Stage 1 Road Safety Audit

Castleconnell Flood Relief Scheme

On behalf of OPW / Limerick City & County Council

July 2024

SCANLON PARK JUNCTION - LONGSECTION
SCALE: H 1:500, V 1:100. DATUM: 20.000

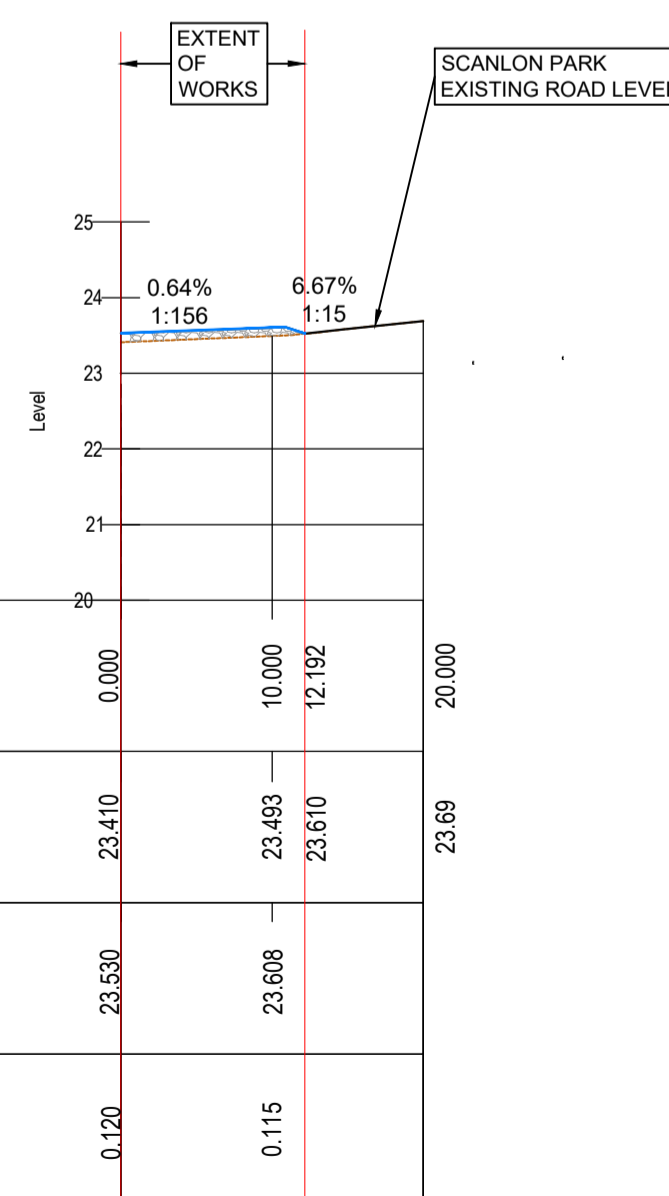
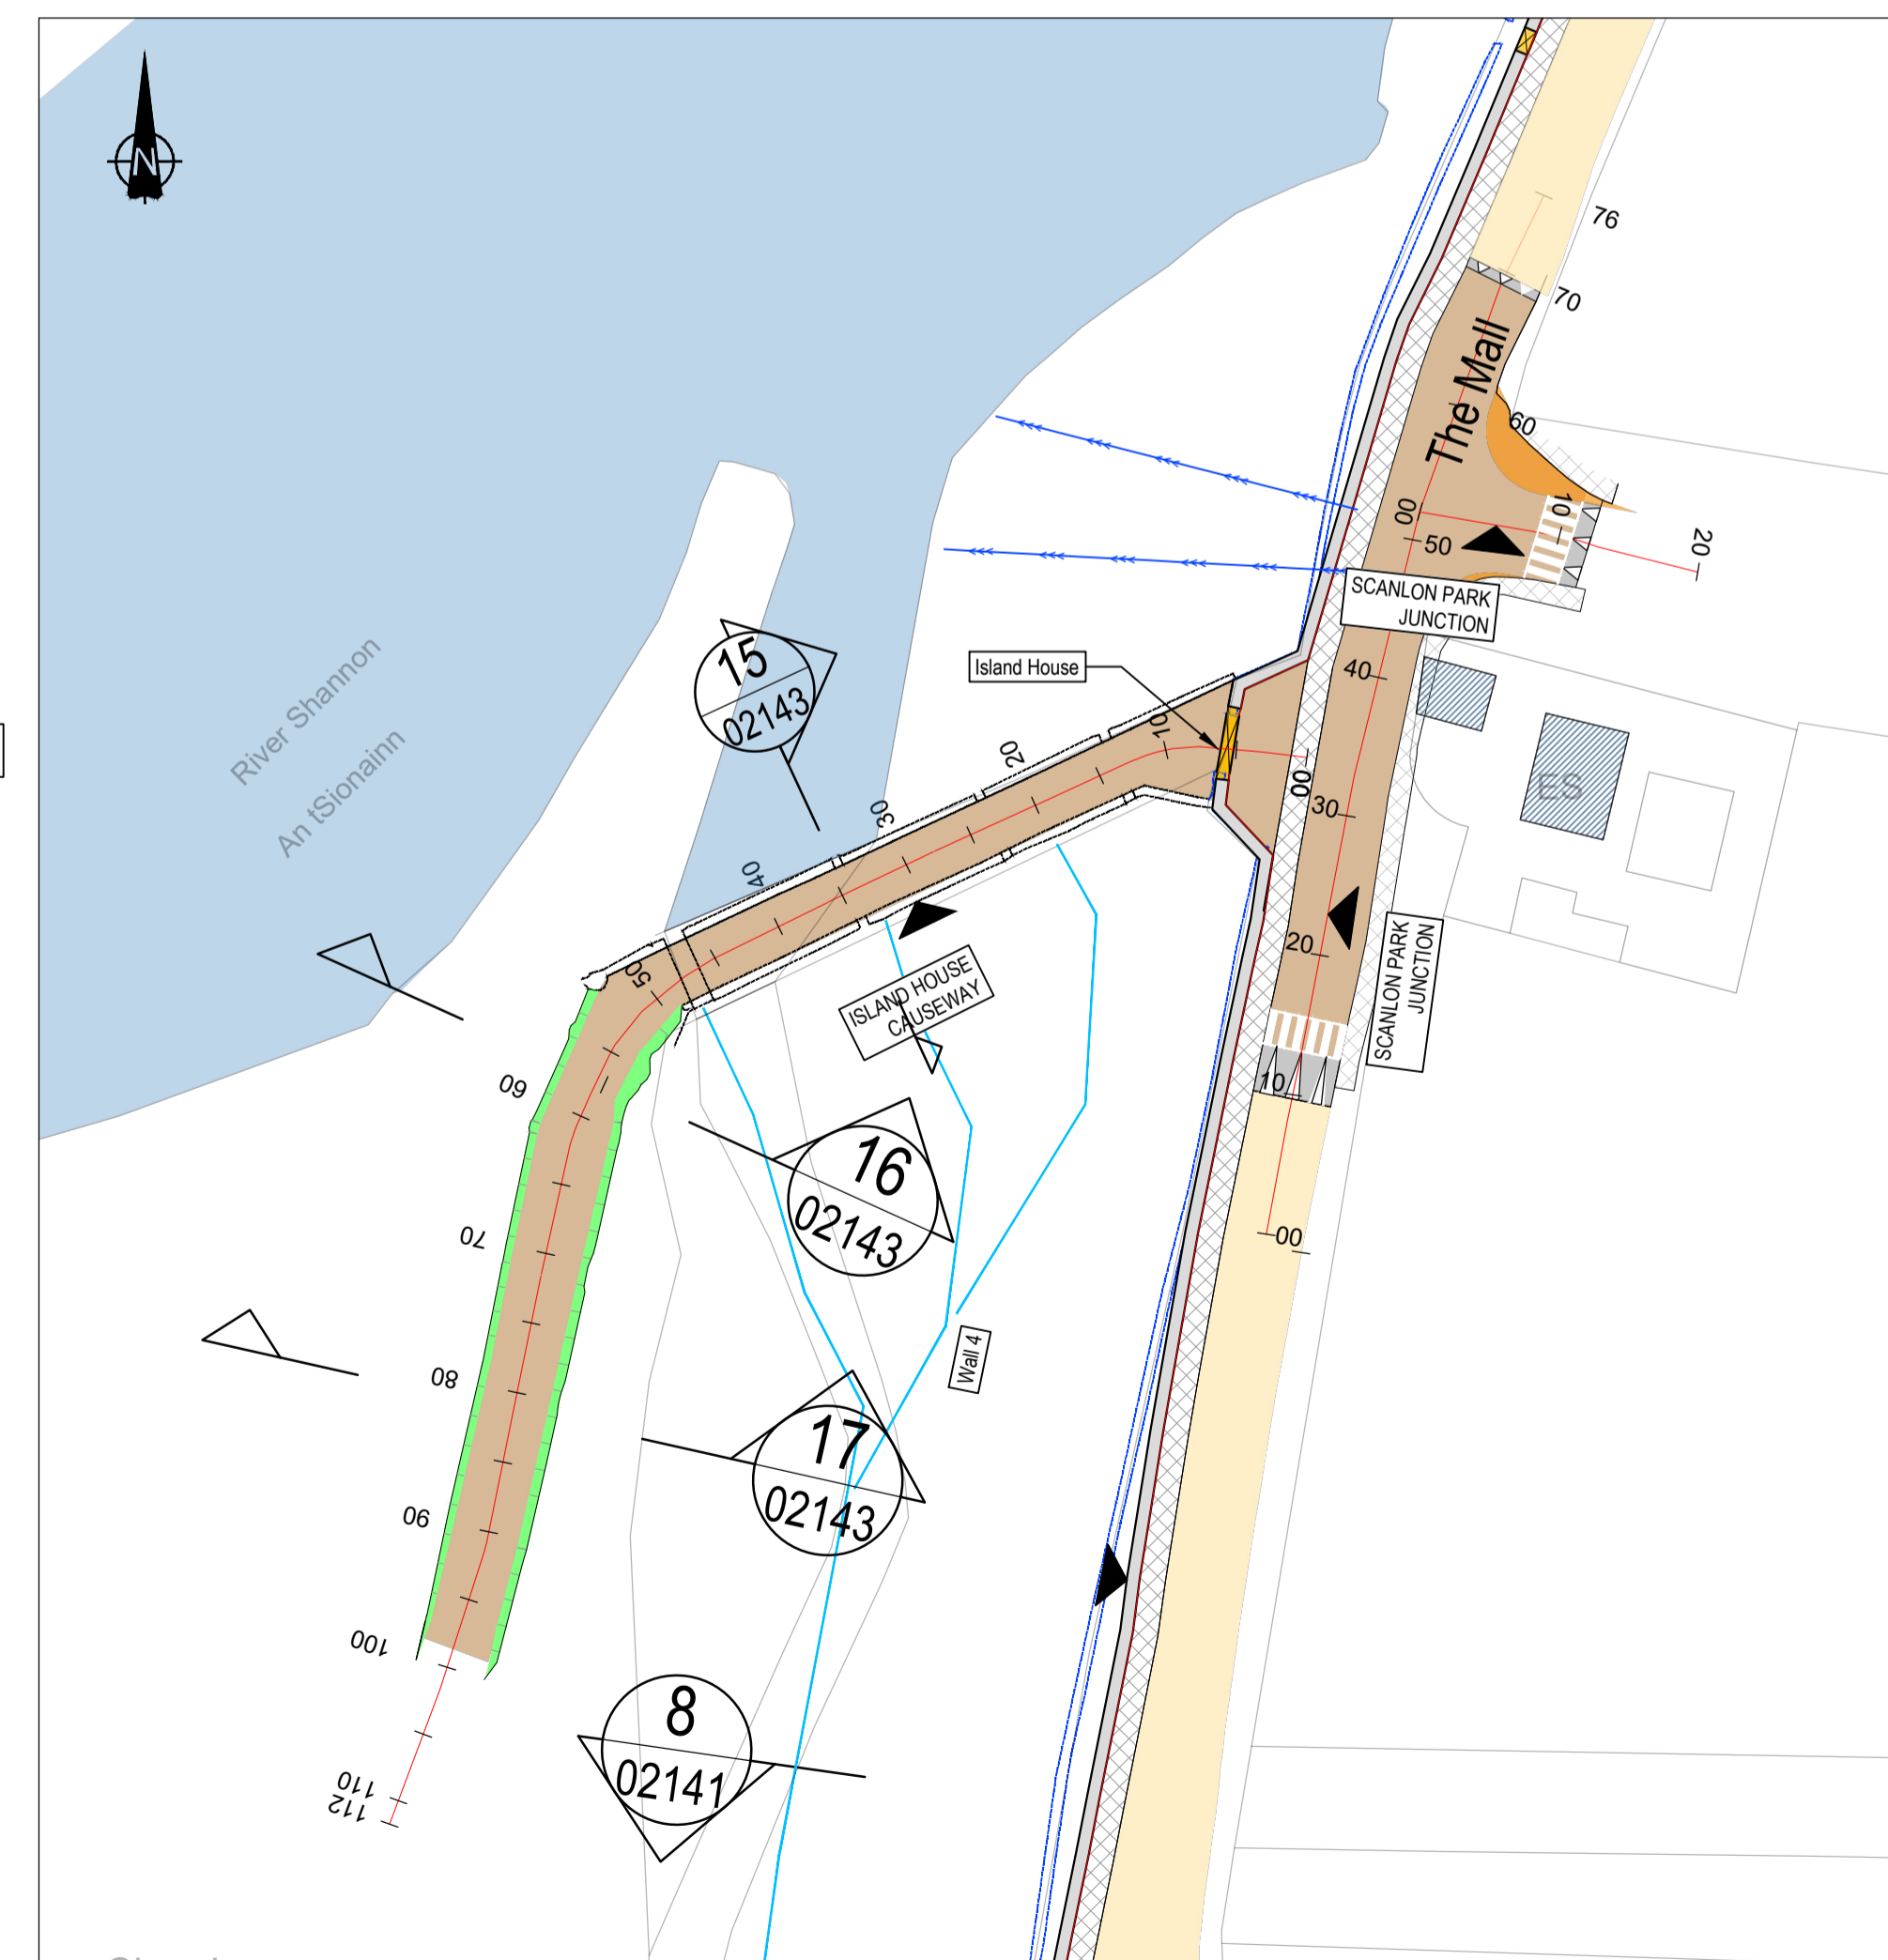
Problem: The design includes for raising of the carriageway near the junction with Scanlon Park. It is assumed by the audit team the footpath will rise at the same gradient at the locations indicated by a ramp on the carriageway, however this gradient is not stated.

Recommendation: The Design Team should ensure footpath gradients comply with approved standards.
